Ribble Valley Borough Council
By email

Your ref 3/2024/0943
Our ref DC/25/327
Date 01-APR-25

Location: Black Moss Farm, Elmridge Lane, Chipping PR3 2NY

Proposal: Proposed erection of eight new agricultural buildings for dairy cattle and associated infrastructure

Figure 6: SuDS Drainage Strategy Summary

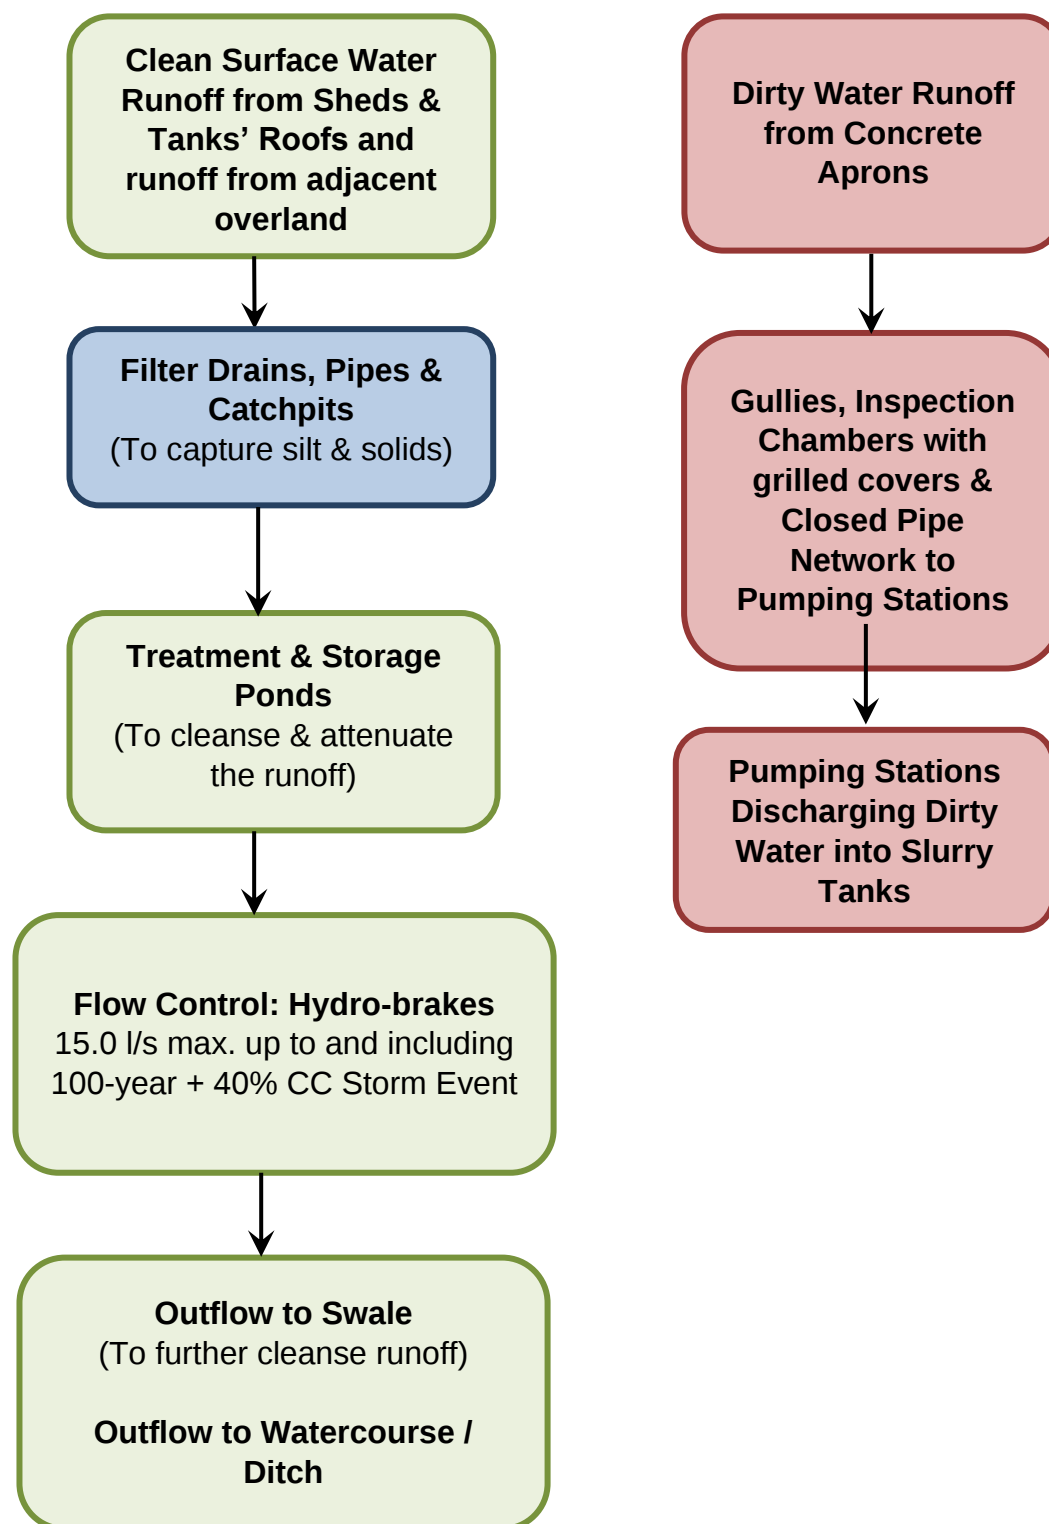
Following our review of the submitted drainage documents; Drainage Strategy Ref: CSH-BML-XX-XX-DR-C-05, Rev P03 Dated 06.08.2024, the plans are not acceptable to United Utilities. We request the drainage plan is updated to include finished floor levels, cover levels and invert levels. The drainage plan also incorrectly shows foul water discharging into the surface water sewers.

Prior to the commencement of development, details of a sustainable surface water drainage scheme and a foul water drainage scheme shall be submitted to and approved in writing by the Local Planning Authority. The drainage schemes must include:

- (iii) Levels of the proposed drainage systems including proposed ground and finished floor levels in AOD;*
- (iv) Incorporate mitigation measures to manage the risk of sewer surcharge where applicable; and*
- (v) Foul and surface water shall drain on separate systems.*
